MEMORANDUM

TO: Jean Fraser, Planner
FROM: David Senus, P.E. & Ashley Auger, E.I.T.
DATE: June 23, 2011
RE: Harborview Townhouses, Level III Final Site Plan Application

Woodard & Curran has reviewed the Response to Comments for the Final Level III Site Plan Application for the Harborview Townhouses located at 127-129 York Street in Portland, Maine. The project includes the construction of a new three story 4,160 square foot (footprint) building to house seven new residential units on an urban infill lot, along with associated site improvements.

DRAWING NO.
C-2

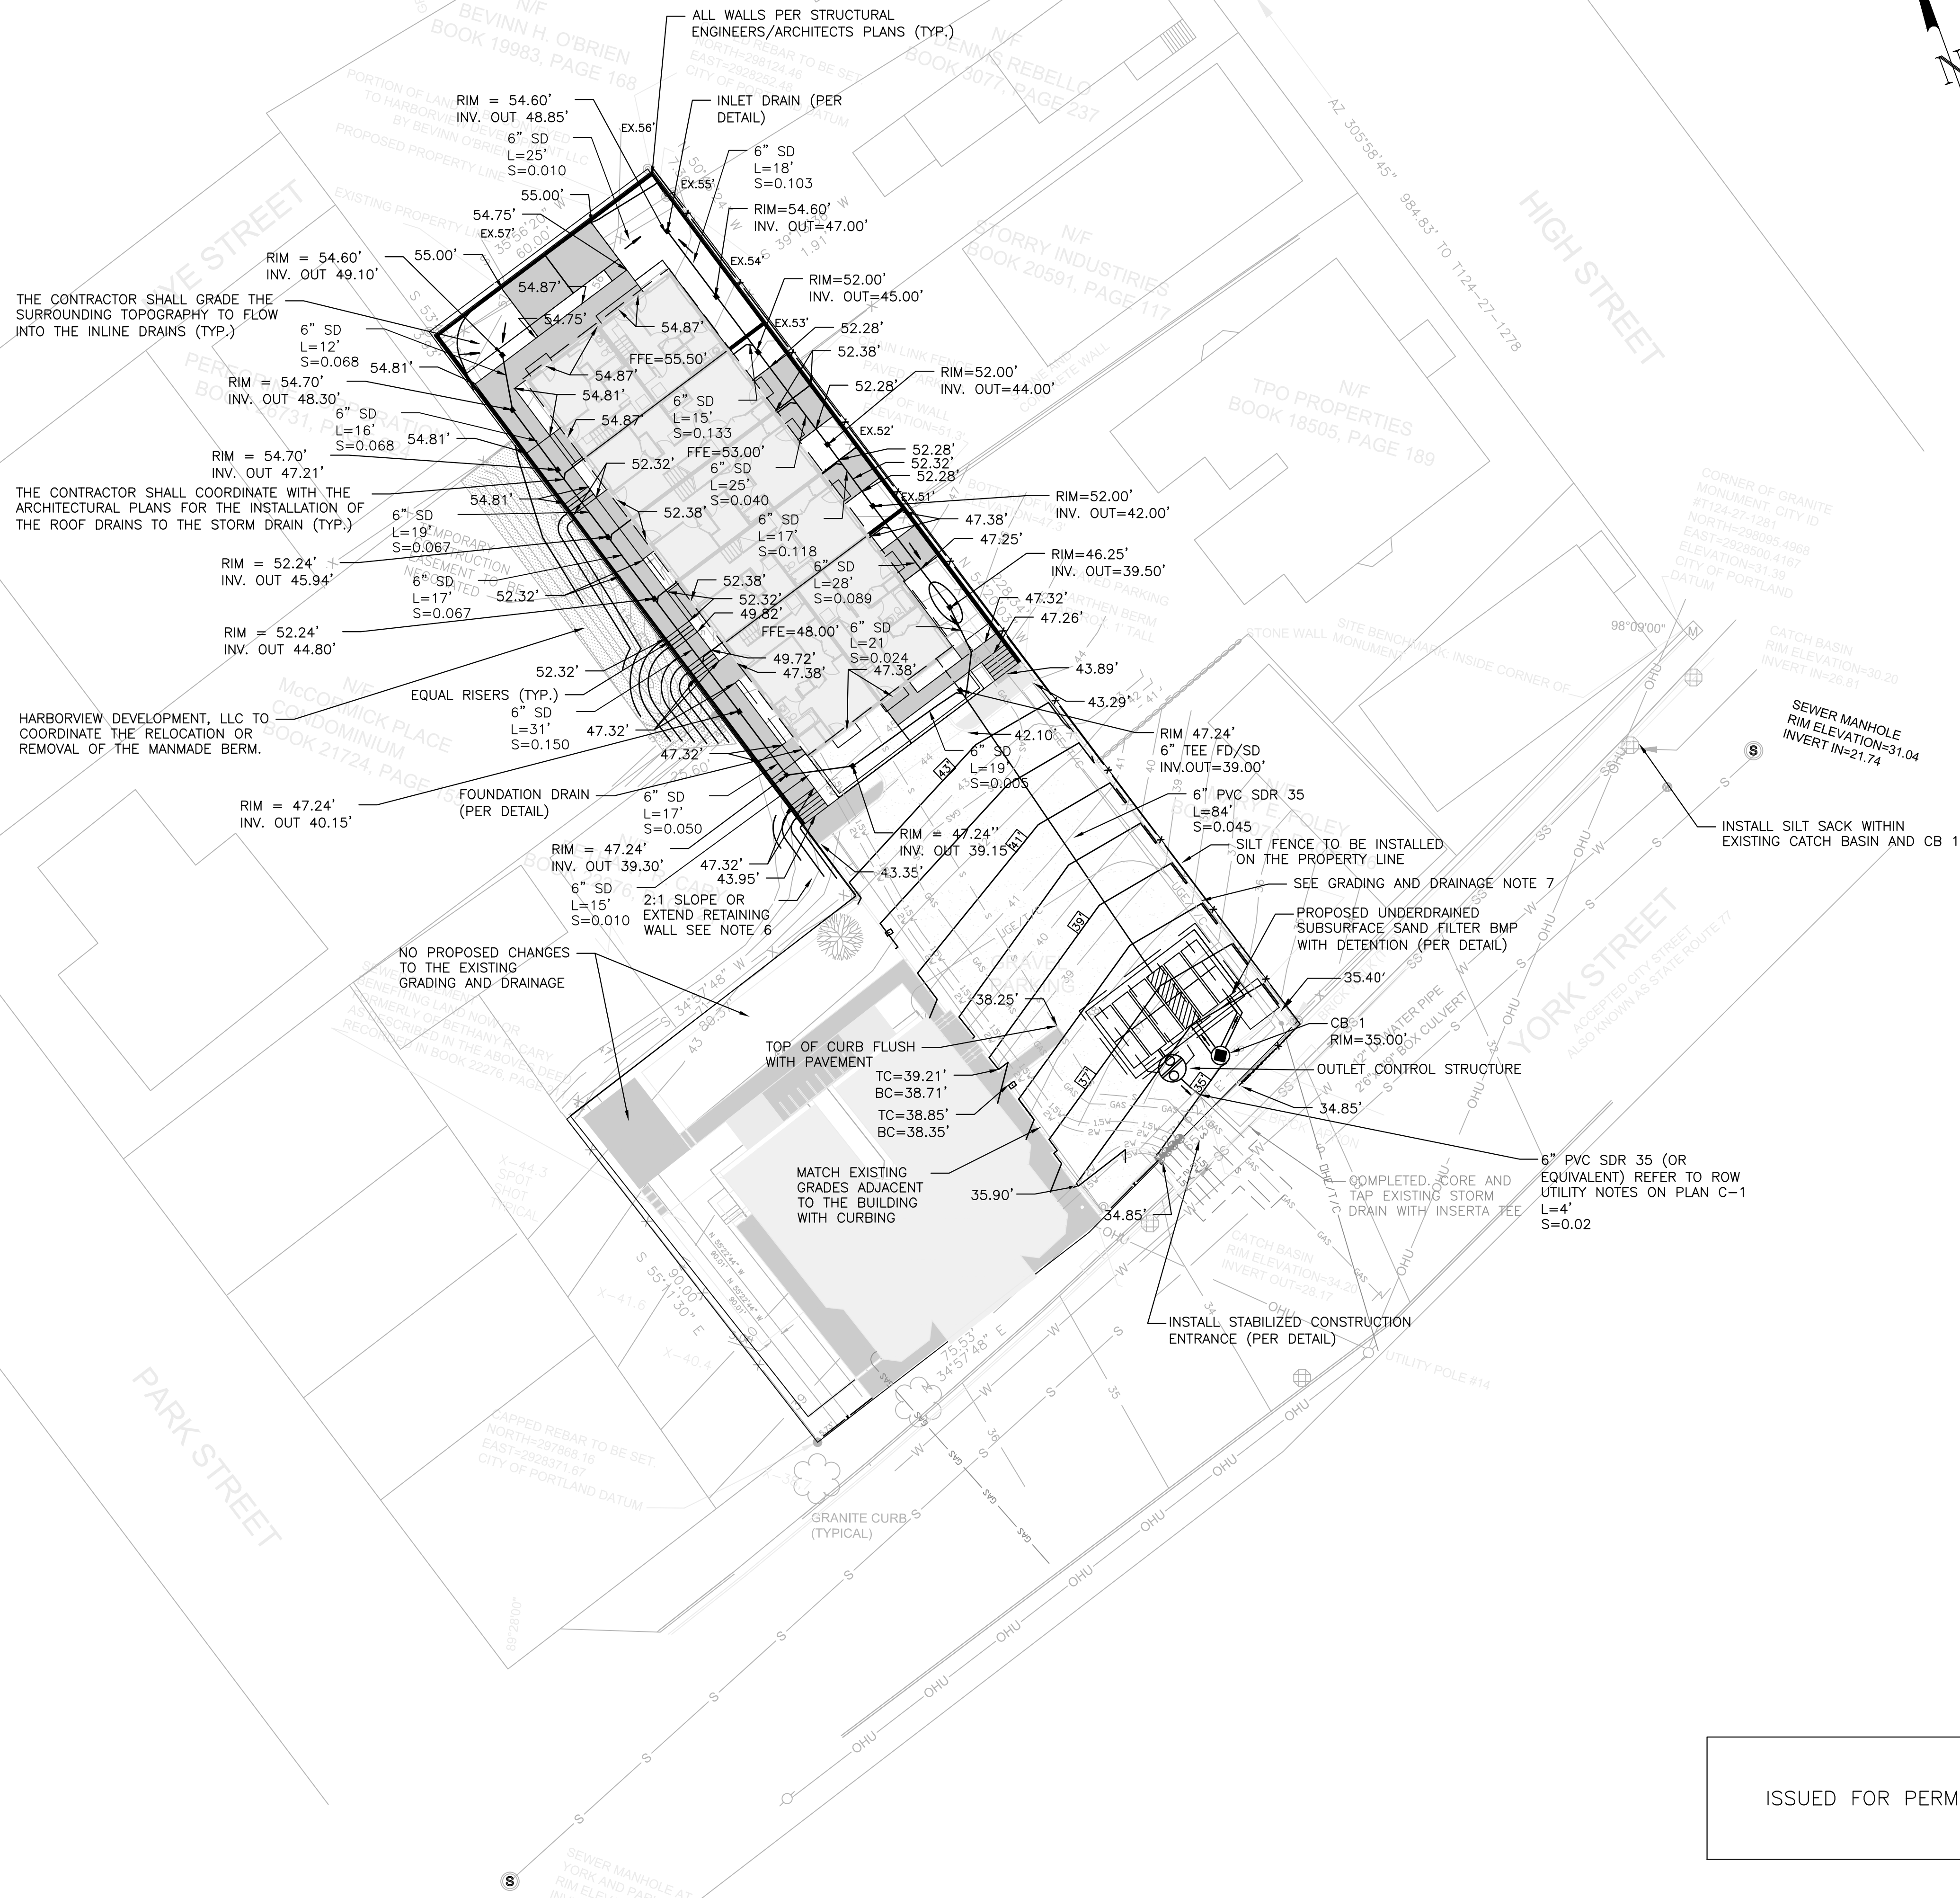
- In the Applicant's response to comments letter, an explanation was provided on how the proposed grading will match into adjacent, existing conditions; however, this is not clearly presented on the most recent plans. Proposed contours along the majority of the perimeter of the property are not shown to connect to existing contours. Additional clarification is needed on the plans, especially along the eastern side of the property and the northwest portion of the parking lot.

- The updated plans show proposed grading on the adjacent McCormick Place Condominium property as a means to match into the existing conditions. Because this work will occur beyond the applicant's property, the applicant must provide appropriate easements or temporary construction rights granted by the adjacent land owner(s).

- The updated plans still do not provide clarity to the location and type of proposed curbing and sidewalks within the site.
- The applicant has provided additional documentation for the Stormwater Maintenance and Inspection Plan. The plan suggests that the Subsurface Sand Filter (SSSF) should be inspected annually. The frequency of SSSF inspections should be revised to reflect the requirements outlined in Section 7.3 of Volume III of the Maine Department of Environmental Protection's BMP Manual: *"The system should be inspected after every major storm in the first few months to ensure proper function. Thereafter, the filter should be inspected at least once every six months to ensure that it is draining within 24 hours to 36 hours."*
